**LU/131/19/PL & LU/132/19/L**

Number 20 Western Road is an Early-mid 19th century, Grade II two-storey Listed Building. It has a slate roof with Horsham slabs at base. It is pebble fronted with red brick dressings on ground floor, whilst the 1st floor is red brick with modillion eaves cornice. The front elevation of the building indicates that it has been adapted and changed over time. Windows are sliding sash to the front elevation.

Having had the opportunity to review the applications, it is clear that the applicant wishes to undertake a significant amount of work to the building, including:

Drawing title
Proposed Changes

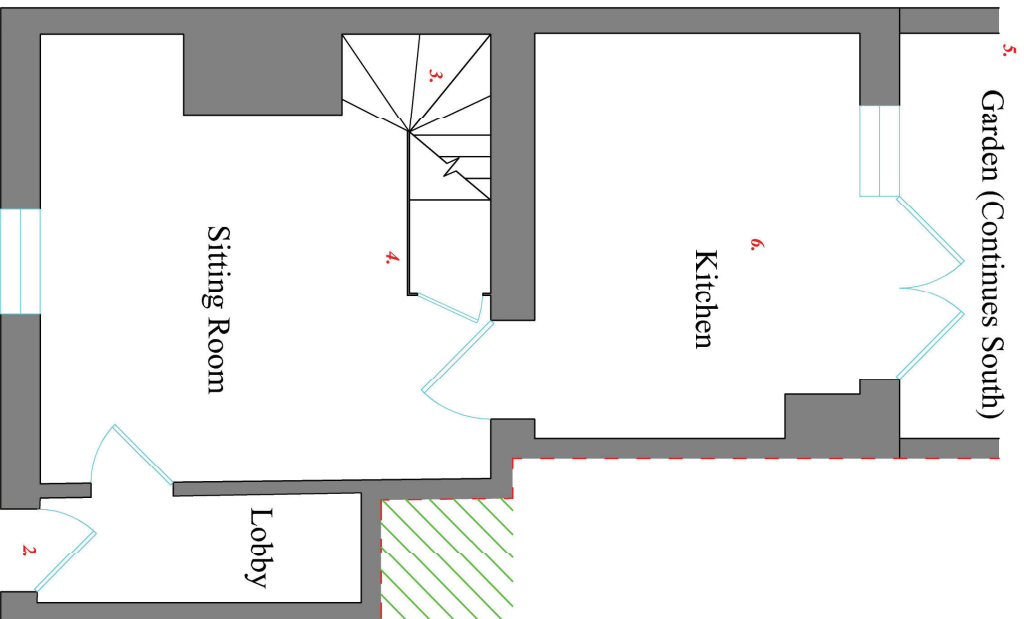
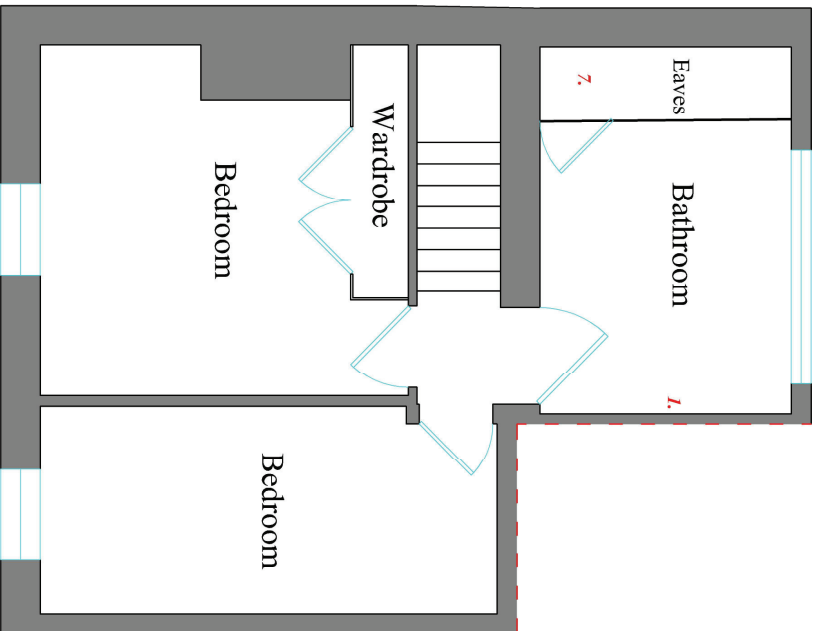
Whilst the concept of repointing is acceptable, it is not clear if the intention is to repoint an entire elevation or more. Could this be confirmed please?

I note that reference is made to the fact that a sample of the mortar used for the original construction would be analysed to ensure that the same one is used for the works. Such a proposal is considered to be appropriate, and suitable for the building, and the impact that the works could have on the external appearance of the building. The style of pointing should be confirmed with the applicant.

Further, the heritage statement indicates that some of the existing brickwork is damaged. If it is to be replaced, it should be undertaken on a like-for-like basis.

The concept of replacing the stairs is considered to be acceptable, subject to them looking like they do now. Works to remove the existing fabric should be undertaken carefully so as to not harm the historic fabric. All historic fabric should also be carefully re-instated.

The intention is to try to repair and restore the front door is supported as it will allow older fabric to remain in-situ. If replacement is required, this should be done on a like for like basis. It might be worth the applicant informing the LPA if the door is to be replaced and provide information to confirm that the replacement will be a direct copy.

Whilst the proposal is acceptable, materials must be used which reflect the existing walling. As before, a mortar sample can be sent for analysis in order to ensure that it reflects the existing material. The style of the pointing should also reflect the property/the existing style.

Drawing title
Rear Elevation

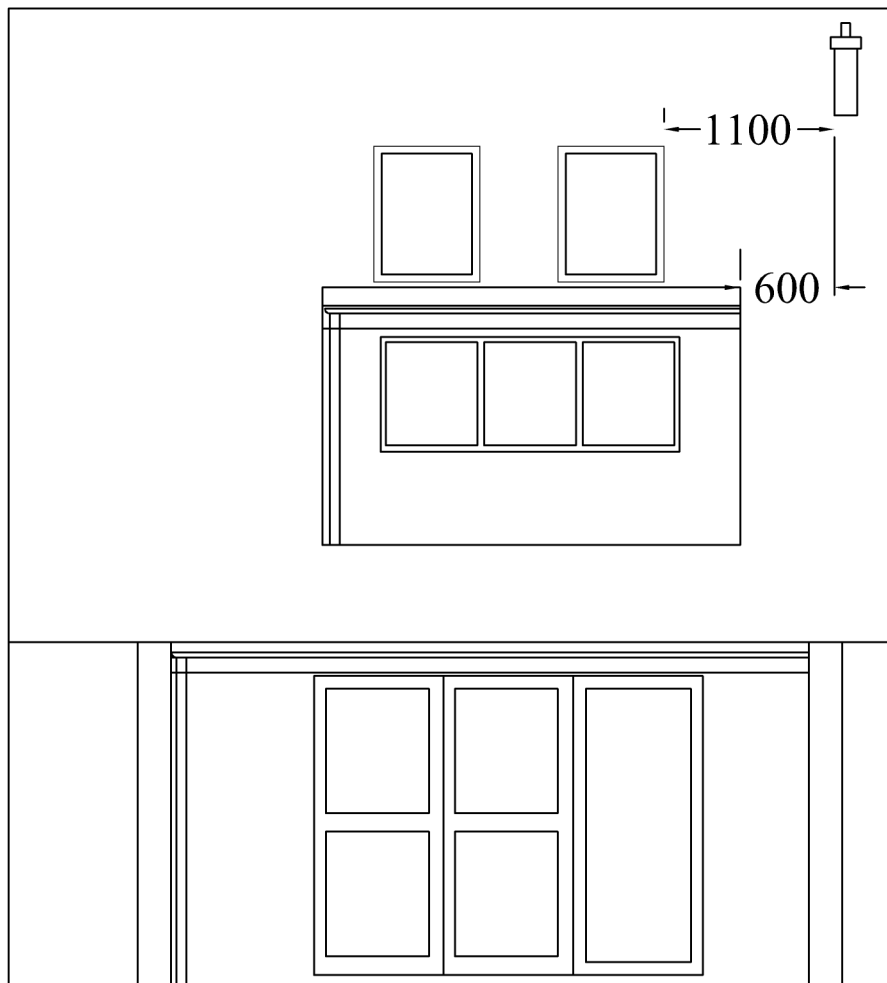
The location and appearance of the flue are considered to be acceptable. For information, it should be treated in a black colour to reduce its impact.

The change of paint colour on the rear elevation is acceptable. This new colour appears to have been previously used on the building and is thought to be acceptable. You may wish to confirm the exact details of the colour, so that it is of heritage standard.

It would be positive if the applicant were to upgrade the existing rear rooflights so that they are of conservation standard.
